Our ref: WA/2018/125260/03-L01
Your ref: 18/00904/F
Date: 12 September 2019

Formation of inland waterways marina with ancillary facilities building, car parking, access and associated landscaping including the construction of a new lake.

Glebe Farm, Claydon, Banbury, OX17 1TD.

Environment Agency response

| Drawing Title PROPOSED SITE PLAN | Drawing Number A05/022 E |

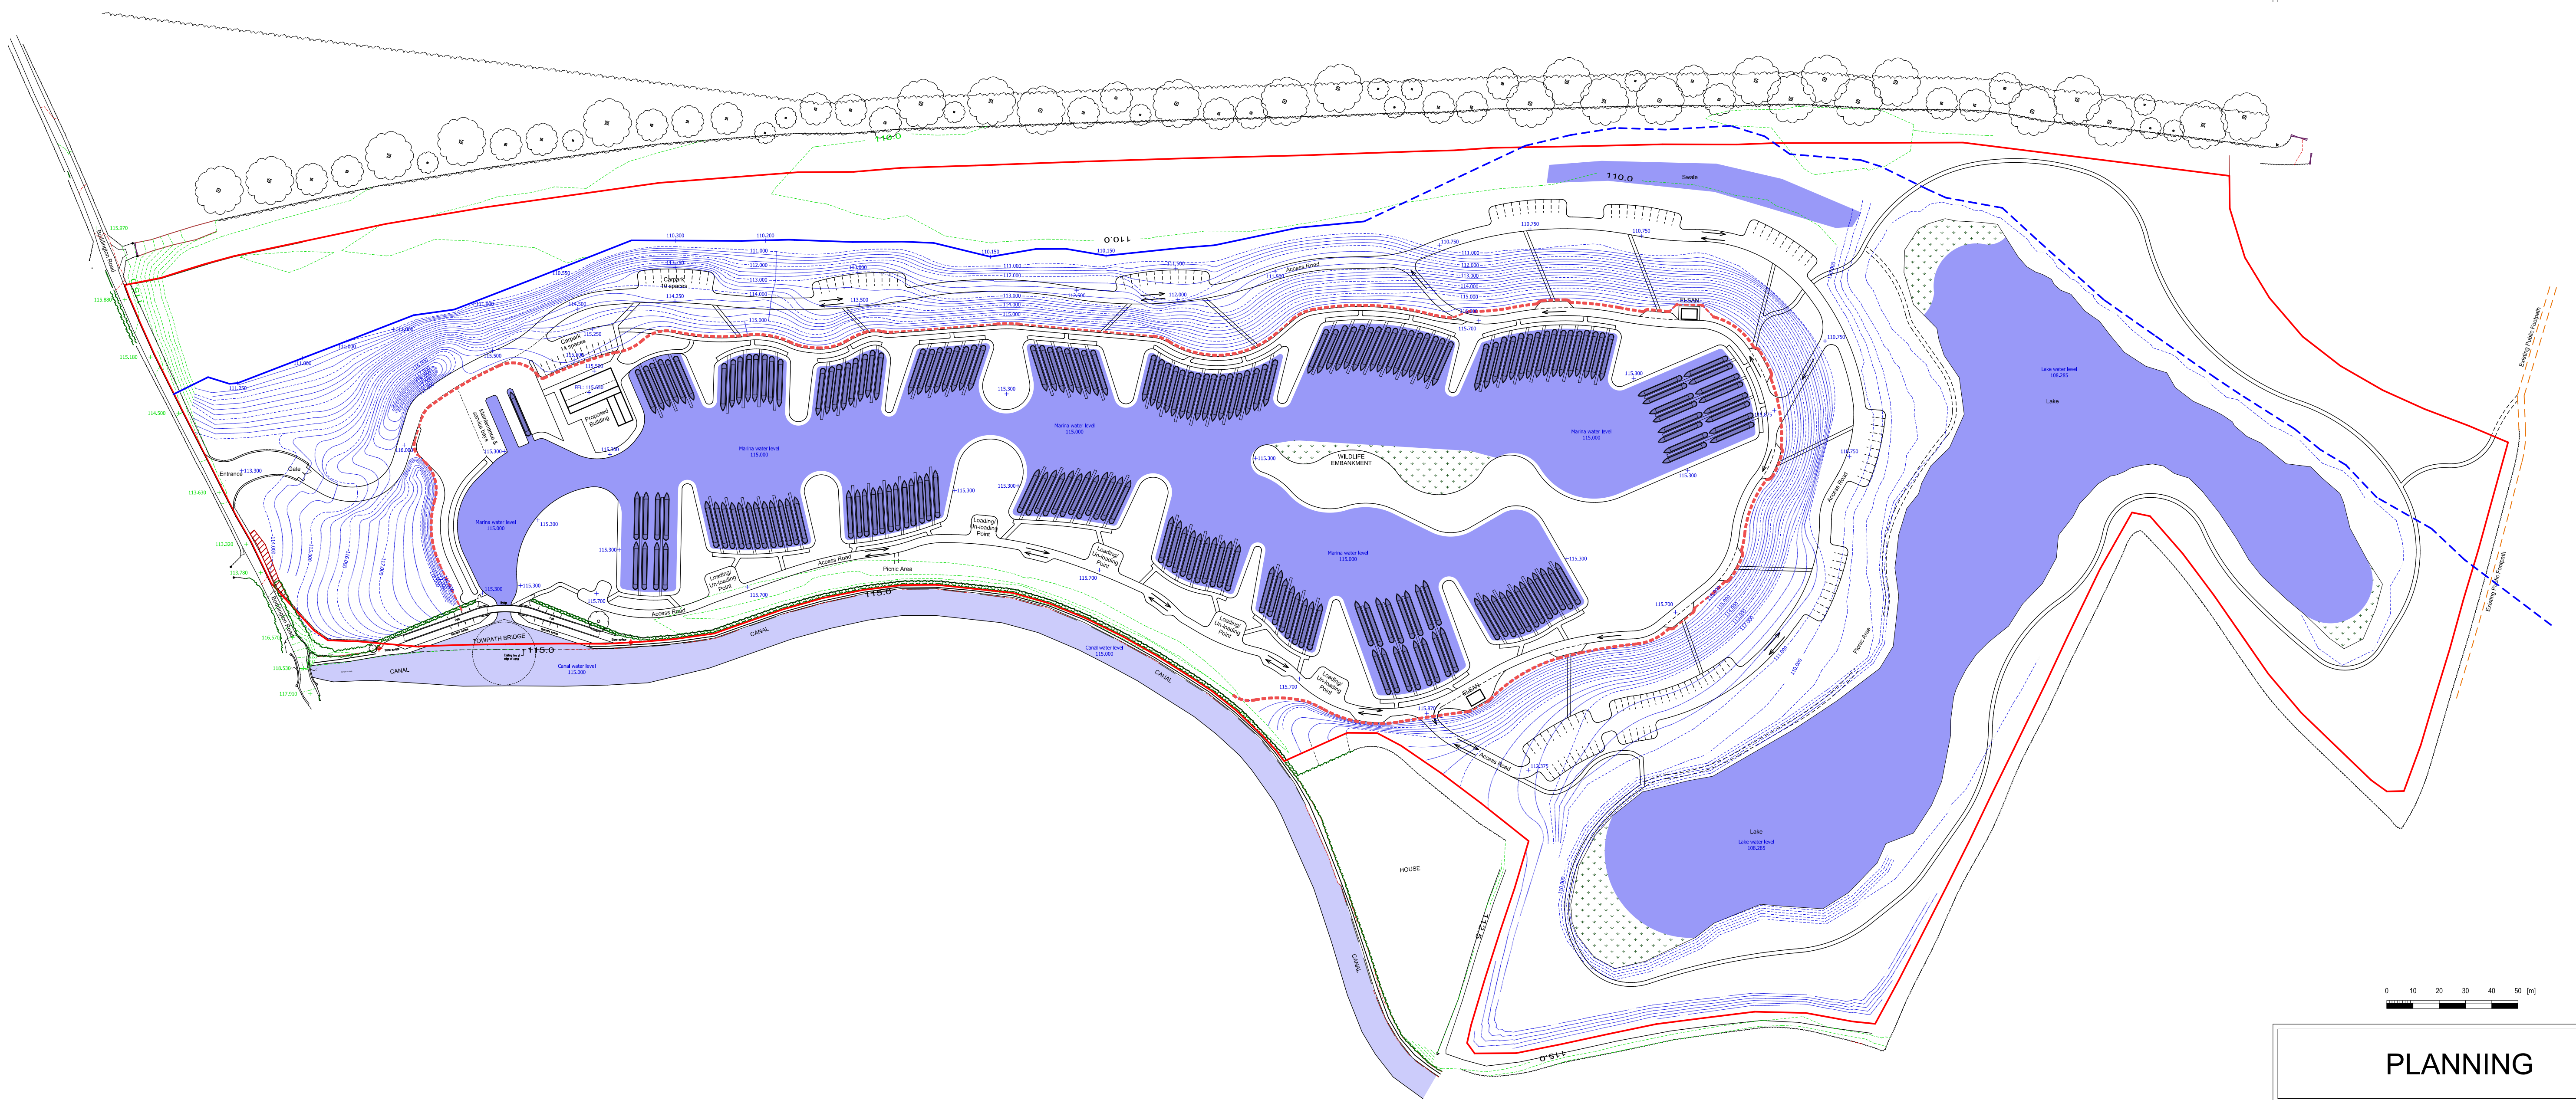
We have reviewed the Flood Risk Assessment (EAS, 1319/2019 Rev: B, July 2019) submitted in support of the proposed development. We are pleased that the development has been re-located to Flood Zone 1 although the red line boundary of the site still lies within Flood Zone 3 (therefore 3b as detailed in our letter dated 24 April 2019). A flood risk assessment should explore the existing flood risk to the site and potential increased risk as a result of the proposed development. Mitigation such as floodplain compensation should then be considered if required in order to maintain the floodplain.

As the red line boundary encroaches into Flood Zone 3, a climate change assessment should still be undertaken using an appropriate allowance. As noted, the current Flood Map isn't based on detailed modelling for this area, rather broad scale generalised modelling which is used to indicate potential flood risk for further investigation.

Therefore there is still some uncertainty as to whether the development will impact on the floodplain. Providing more confidence in this by assessing the 1% AEP plus climate change extent is essential given that the base of the earth work's in some locations run exactly along the edge of the mapped Flood Zone (Site Plan, dwg no: A05/020 E, 01/07/2019). As the development has been re-located to an area of lower flood risk, full detailed hydraulic modelling may not be appropriate now but other methods should be used to improve confidence in the FRA's conclusions.

The applicant can overcome our objection by submitting an FRA which covers the deficiencies highlighted above and demonstrates that the development will not increase flood risk elsewhere and where possible reduces flood risk overall. If this cannot be achieved we are likely to maintain our objection to the application.
